**PRELIMINARY DRAINAGE REPORT
FLYING HORSE NORTH PRELIMINARY PLAN AND
FINAL DRAINAGE REPORT FOR FLYING HORSE NORTH FILING NO. 1**

CCES COMMENT RESPONSES

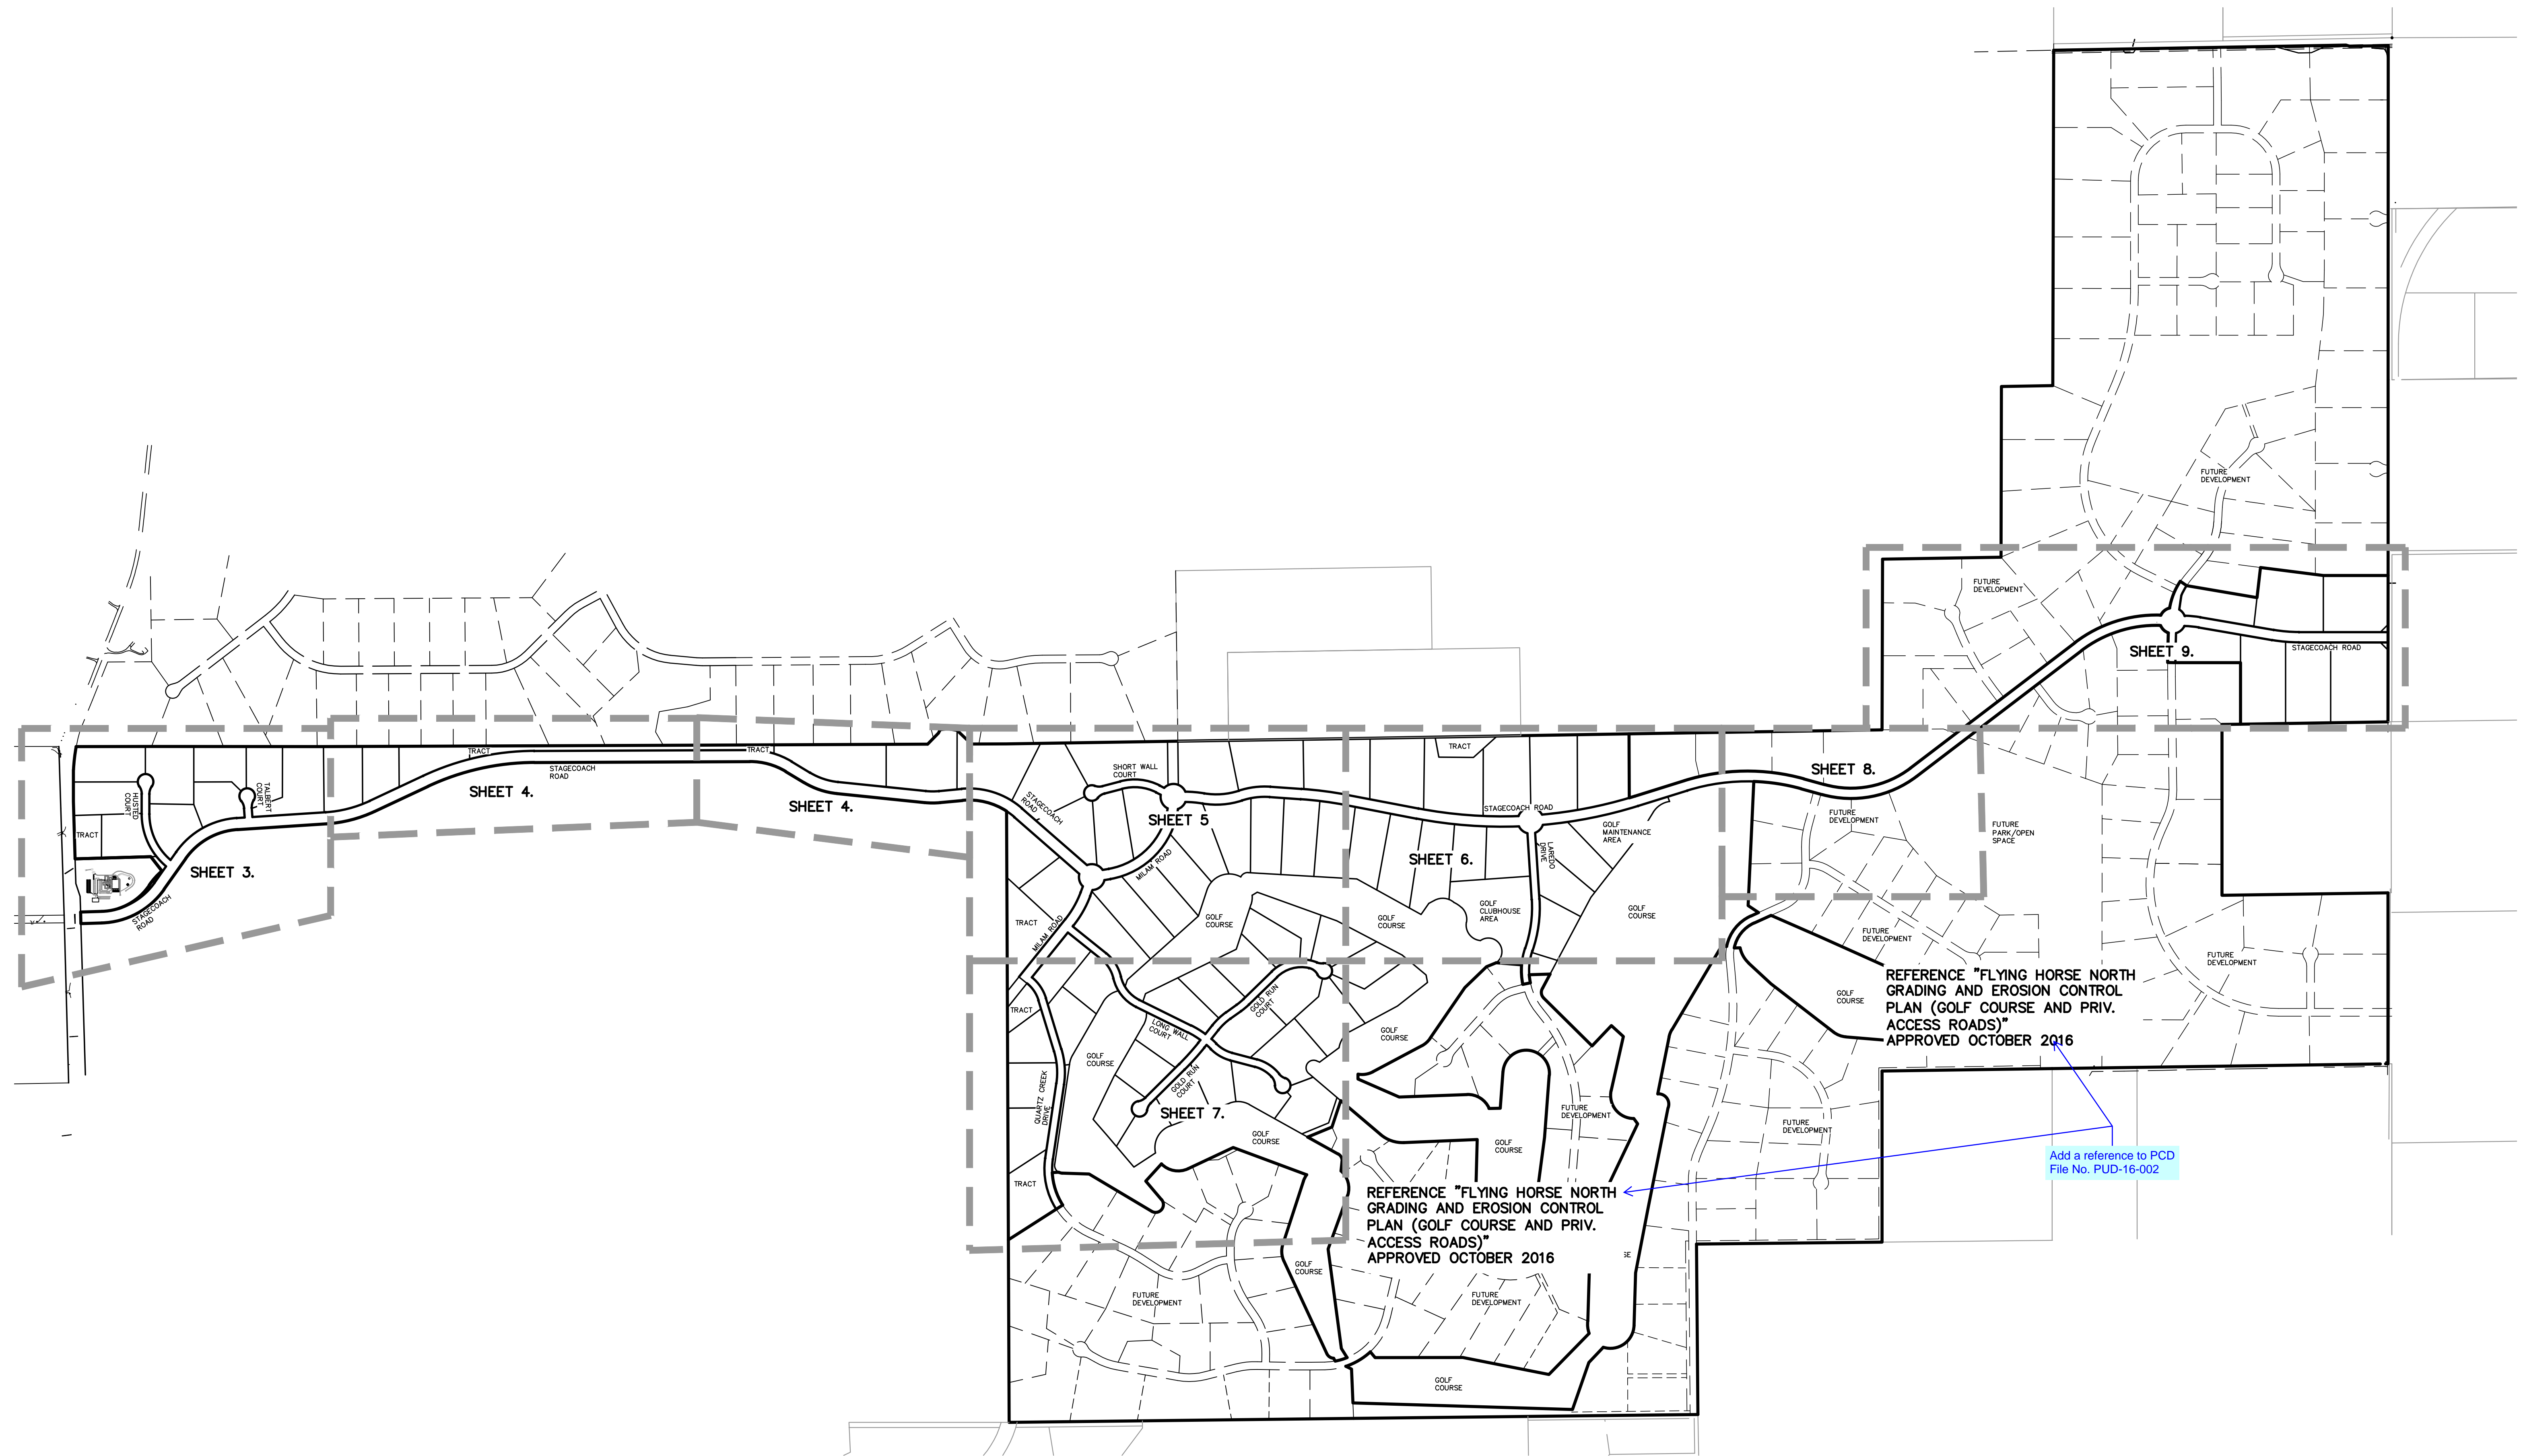
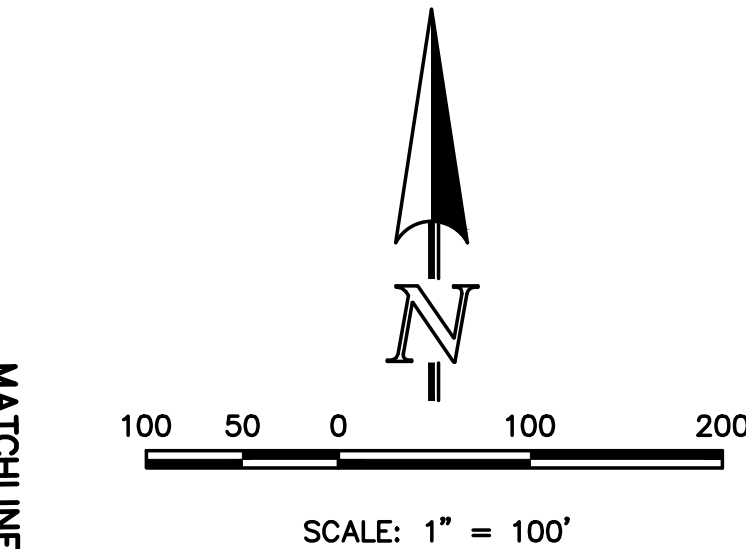
Identify the trigger for removal of the TSB.
05/30/2018 ✓

← Identify the trigger for removal of the TSB.

BS-2B
updated on map
